OBJECTION TO PLANNING APPLICATION 32672
Site: the Garden of 2 St John's Close, Read BB12 7RL
Planning Portal ref PP 09476642

I write as the occupier of [REDACTED] My bungalow directly faces this garden - upon which the applicants want to build a totally inappropriate development.

Proposed Dwelling
EXISTING SITE LAYOUT

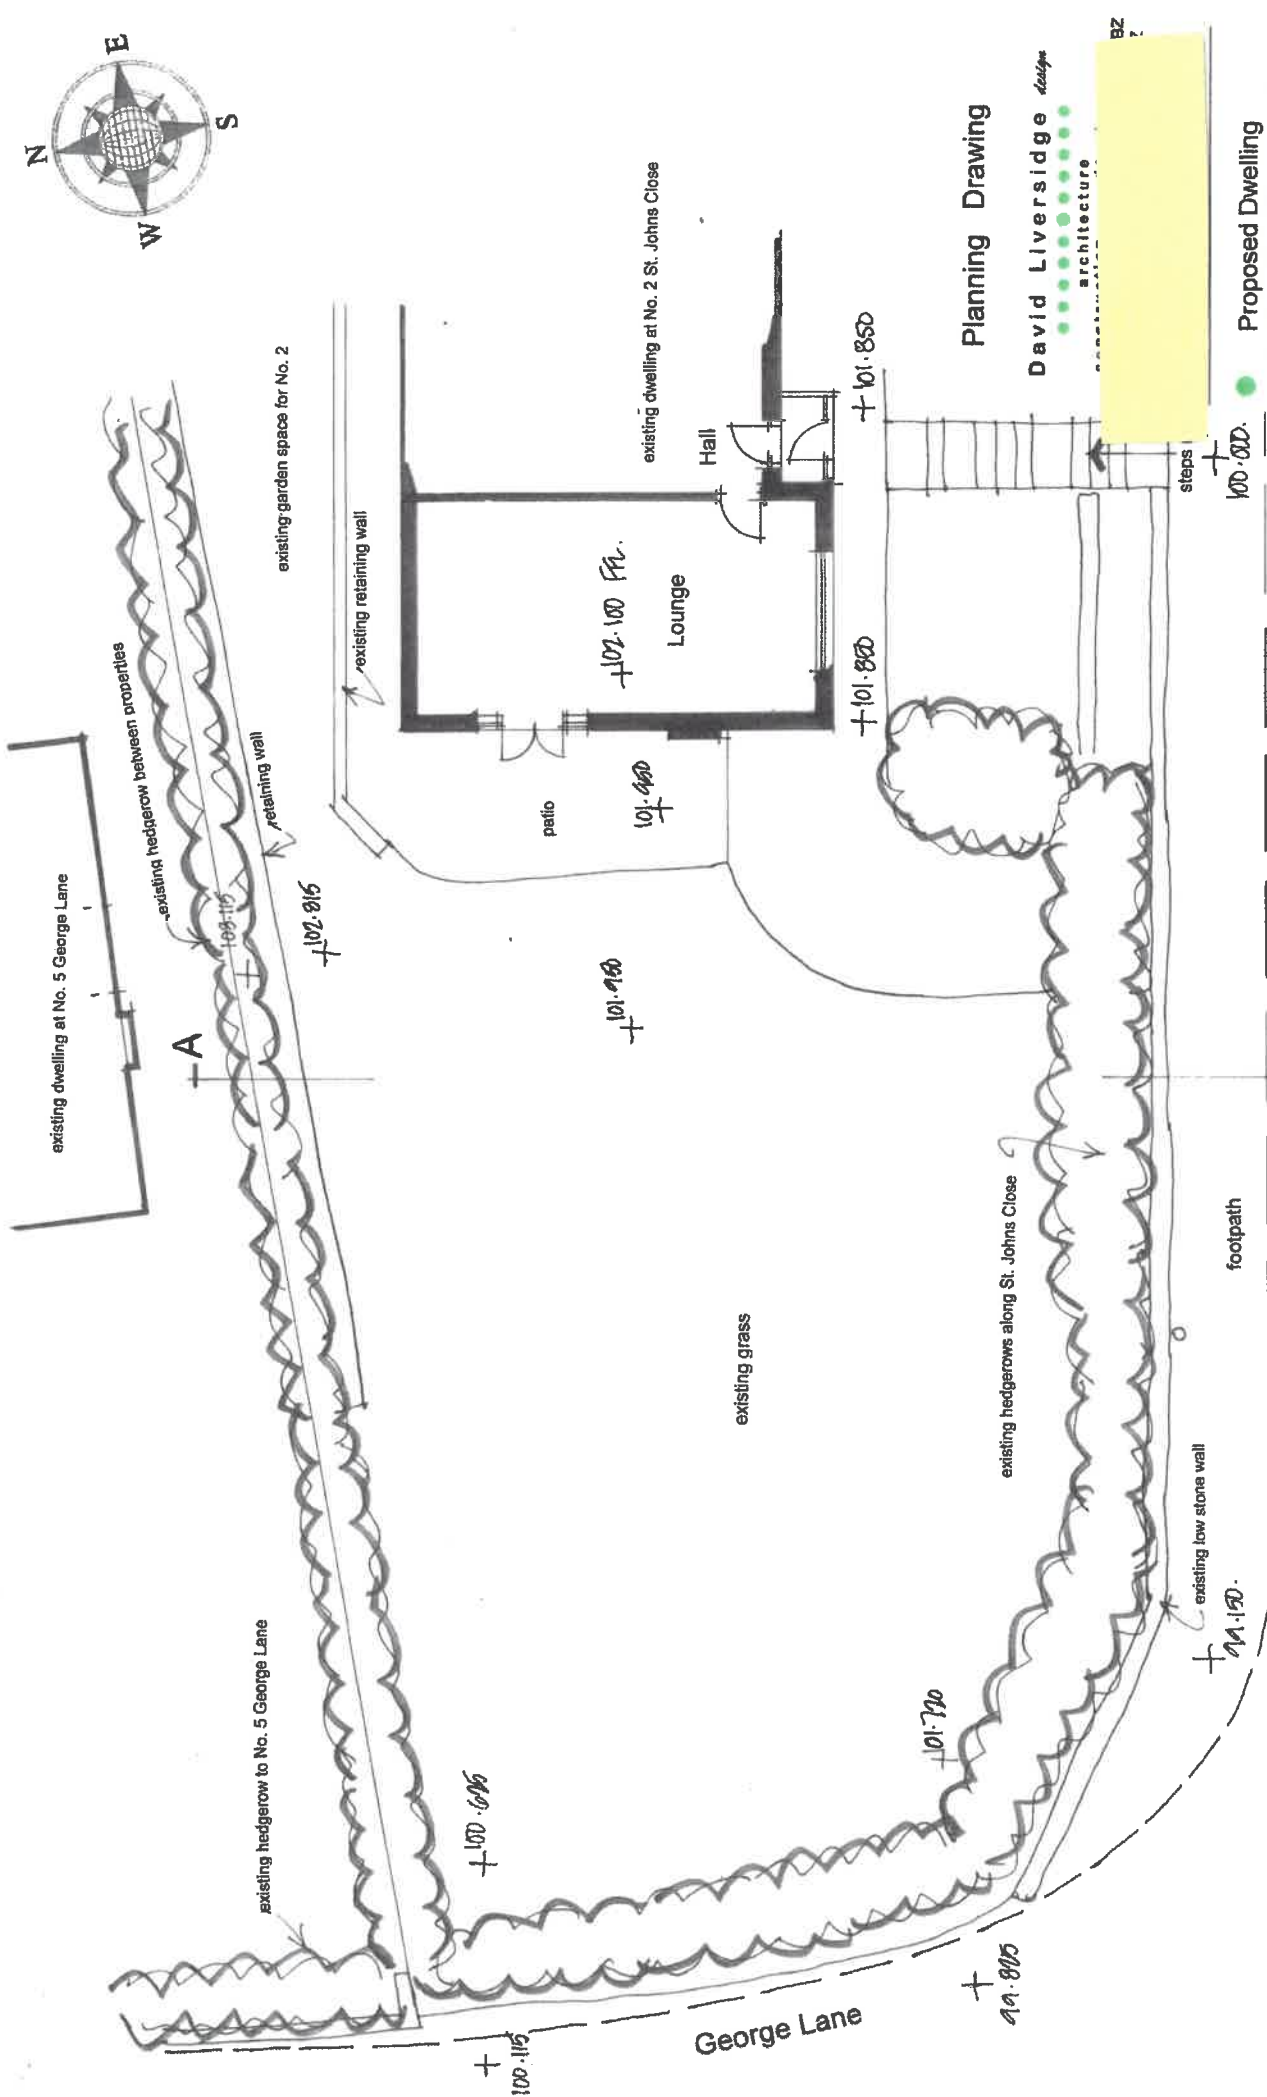
4. **Invasion of Privacy:** (i) It is not possible to tell from the submitted plans precisely which first floor room of the current house faces the site, but it is clear from the submitted 'existing' plan that no 2 St John's Close has large windows directly facing the site at both ground and first floors. The ground floor of no 2 has a pair of glazed doors with additional windows which would face the back of the proposed house, literally only a few metres from the back wall of the new house, so adversely affecting the amenity and residential enjoyment of the existing house at no 2 and its future occupants. (ii) The main aspect of the new house, at both its ground and first floors, would face onto George Lane - looking directly into my house, facing

Proposed Dwelling  
DWELLING PLANS

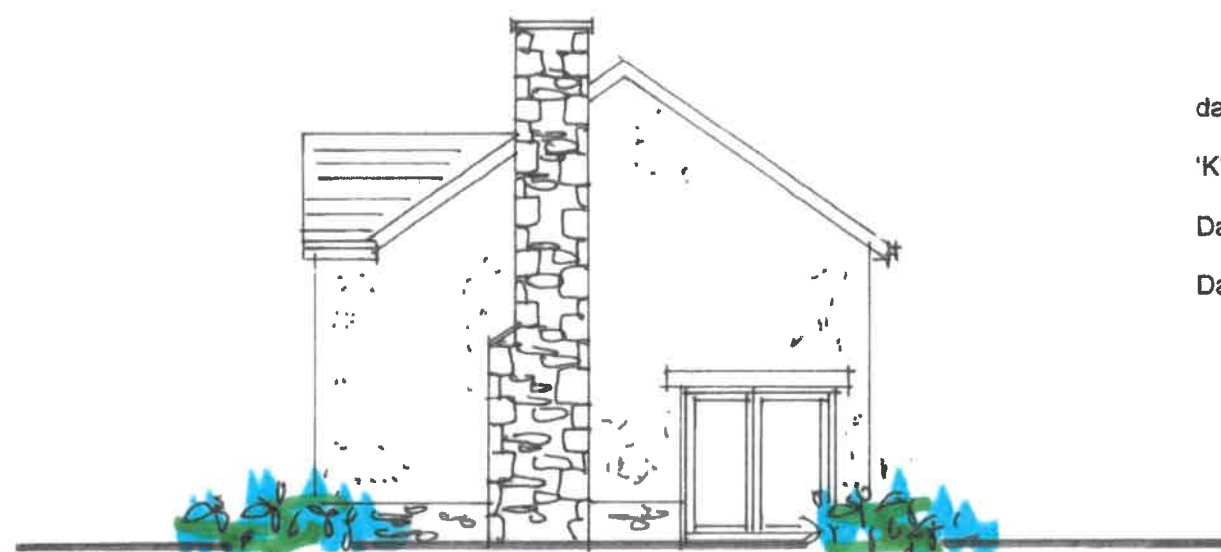
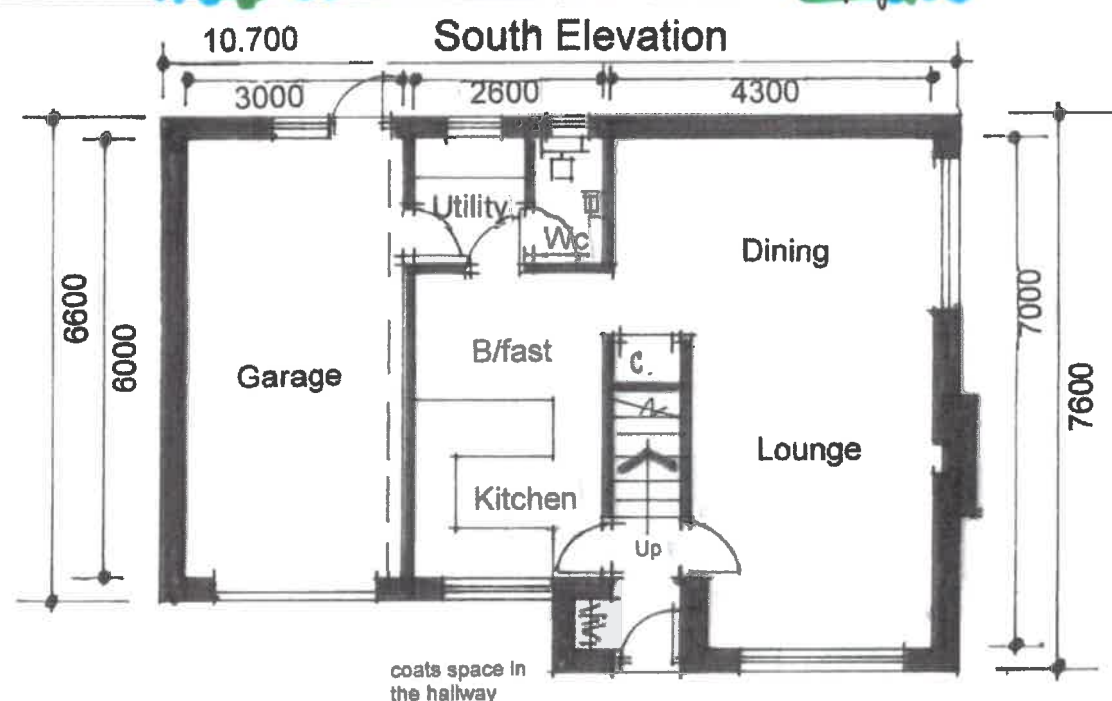
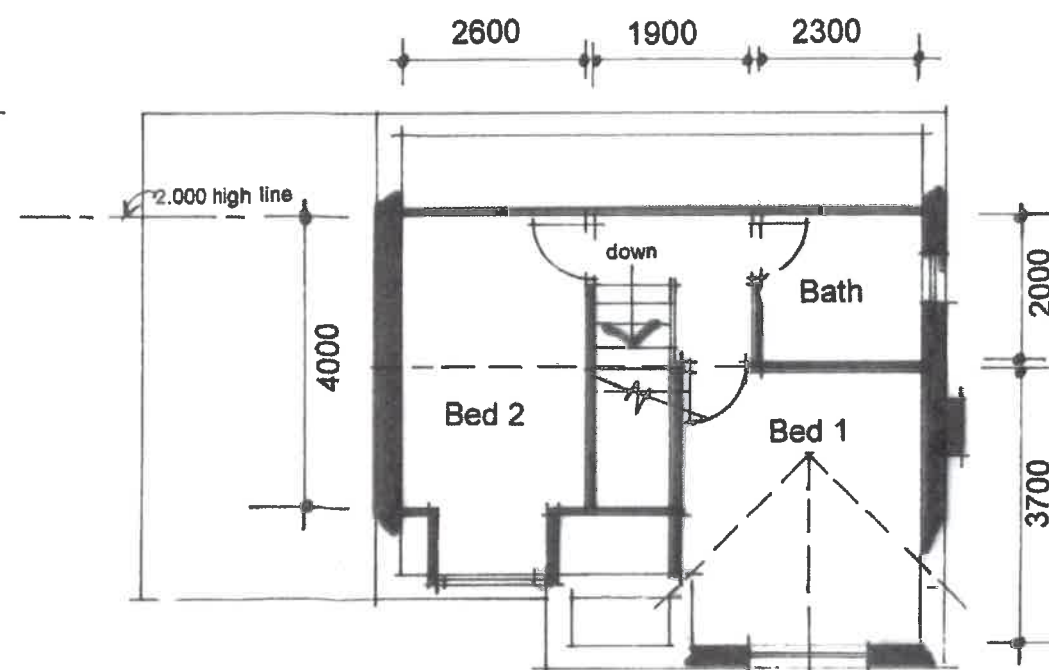
2. **Inappropriate Design:** The proposed two storey house is literally right up against the boundary with the existing house. The new house would therefore have no useable private garden. In seeking to place the new house in this inappropriate location the new dwelling is shown to be forward of the effective 'building line' of George Lane, and so would significantly adversely affect the appearance of the street and damage the visual amenity of this part of the village in an unacceptable way. As is evident from the locations of, for example, no 1 St John's Close and 7 Tennyson Avenue and their gardens (see submitted location plan) this garden was planned as just that - a garden - not a development site.

the only window to my kitchen-dinning room, invading its privacy and destroying the enjoyment of this important room in my small bungalow.
